Application no: **3/2023/0038**

Address: **Brentwood Pendleton Road Wiswell BB7 9BZ**

Proposal: **Proposed new vehicular access.**

PROPOSED VEHICULAR ACCESS

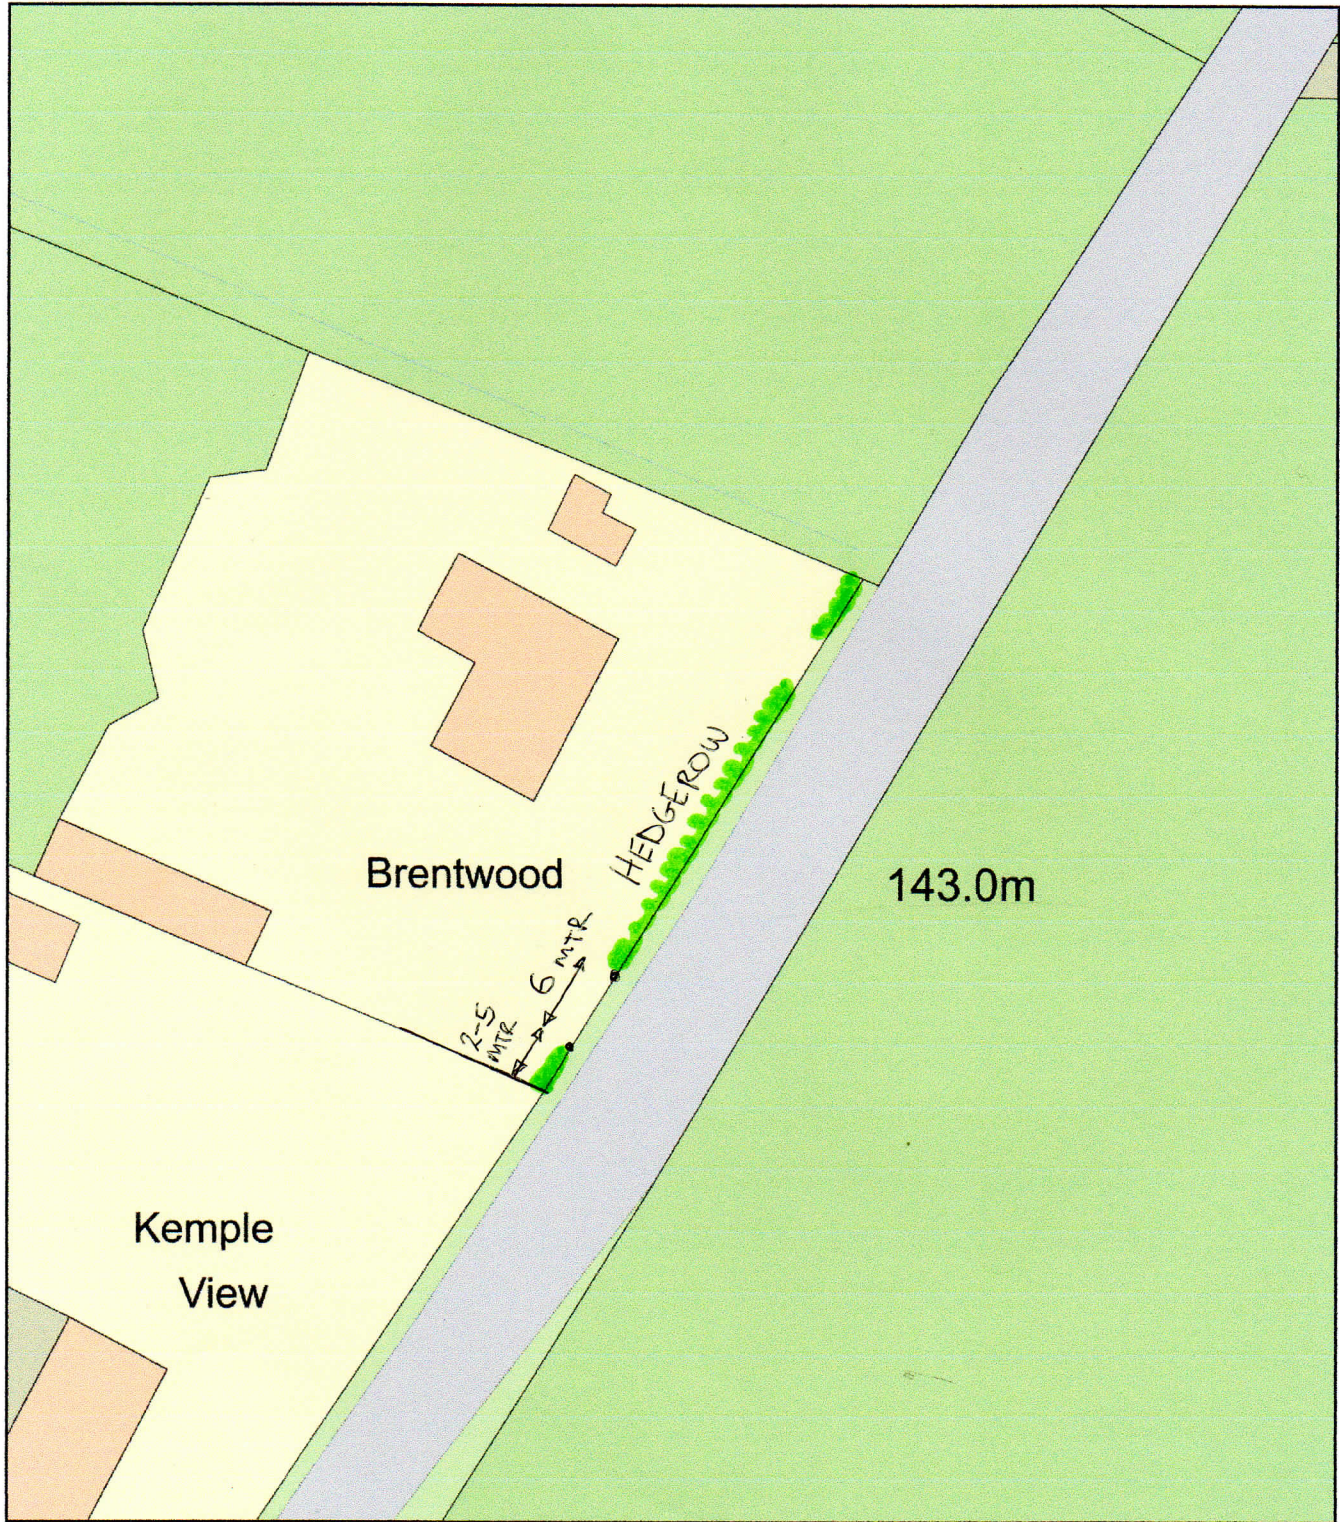
The LHA have reviewed the drawing titled "Proposed Vehicular Access "and are aware that the proposed access will be 6m wide, which complies with the LHAs guidance when serving a single dwelling.
